Application No: R/215/25/HH

Dear Sir/Madam,
Town & Country Planning Act 1990 (as amended)
Town & Country Planning (Development Management Procedure) (England) Order 2015
Application No: R/215/25/HH
Site Address: 21 Sutton Avenue Rustington BN16 2ES
Description of works: Single storey rear extension.

Drawing:  
**Plans and elevations as proposed**

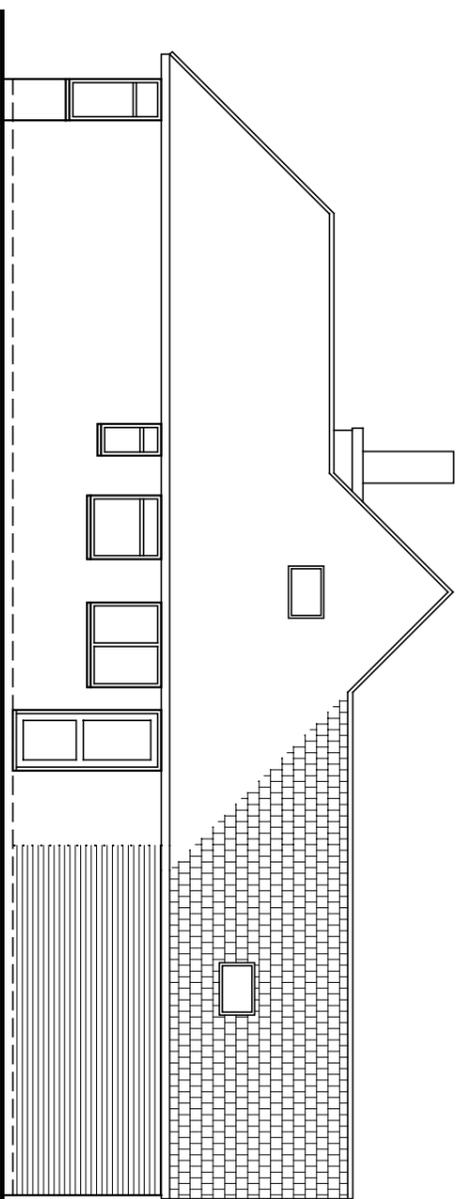
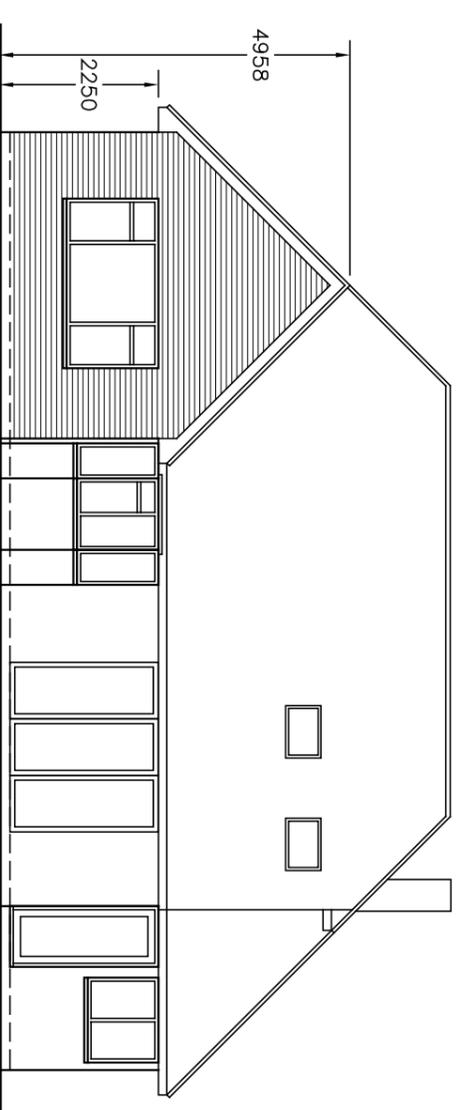
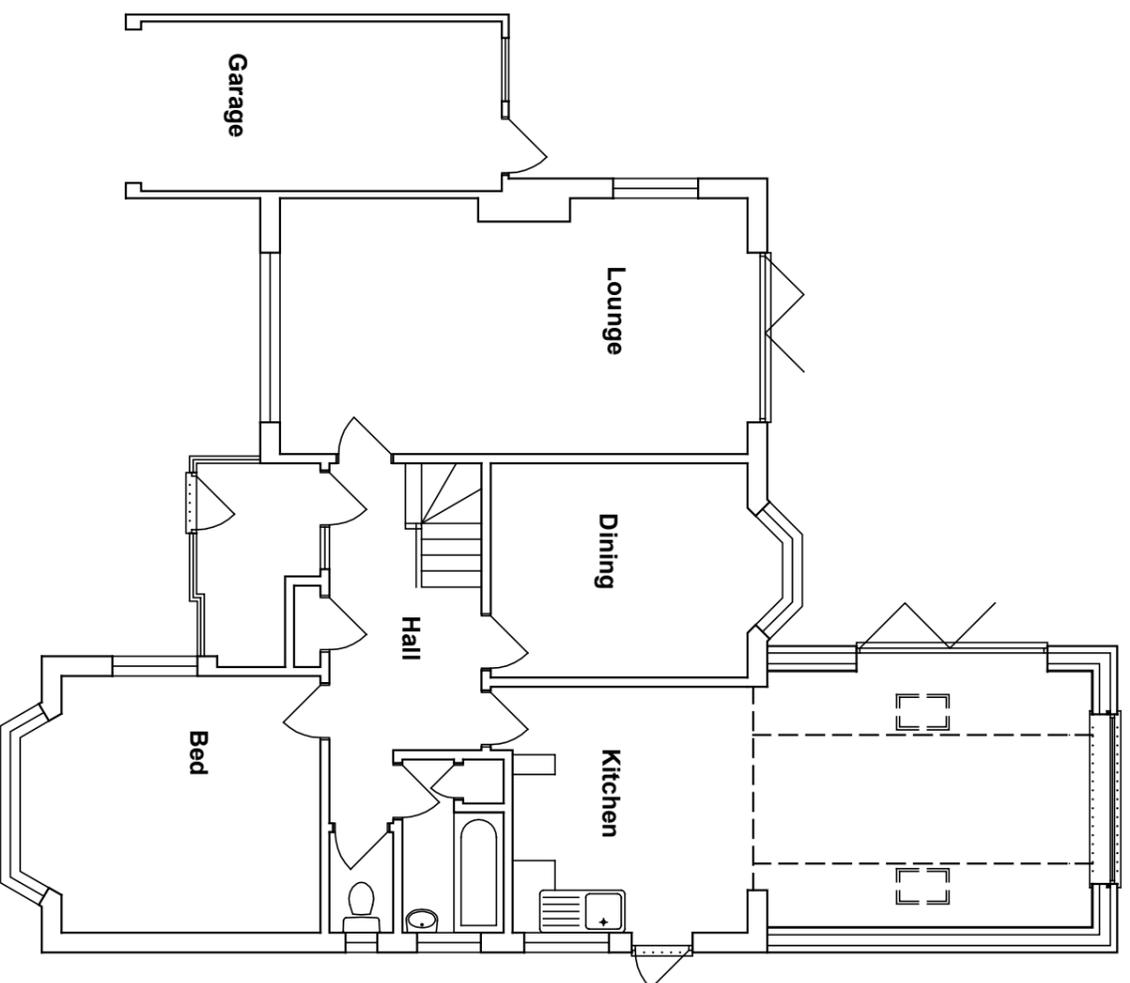
THOMPSONS EXTENSION ON " MY SOUTH SIDE BORDER FULLS WITHIN A "45 DEGREE RULE" ANGLE TAKING MY CLOSEST WINDOW, ,LIVING ROOM ,CENTRE OF WINDOW

HAS BEEN MEASURED FROM CENTER OF MAIN LIVING ROOM WINDOW WHICH IS CLOSEST TO THEIR P[LAN]S EXT.

Thompson family are trying to build within "45 degree angle" you will see on their plans,which will block light, heat push us both into dark ,see centre of main living room window and

their plans for extension fall in angle
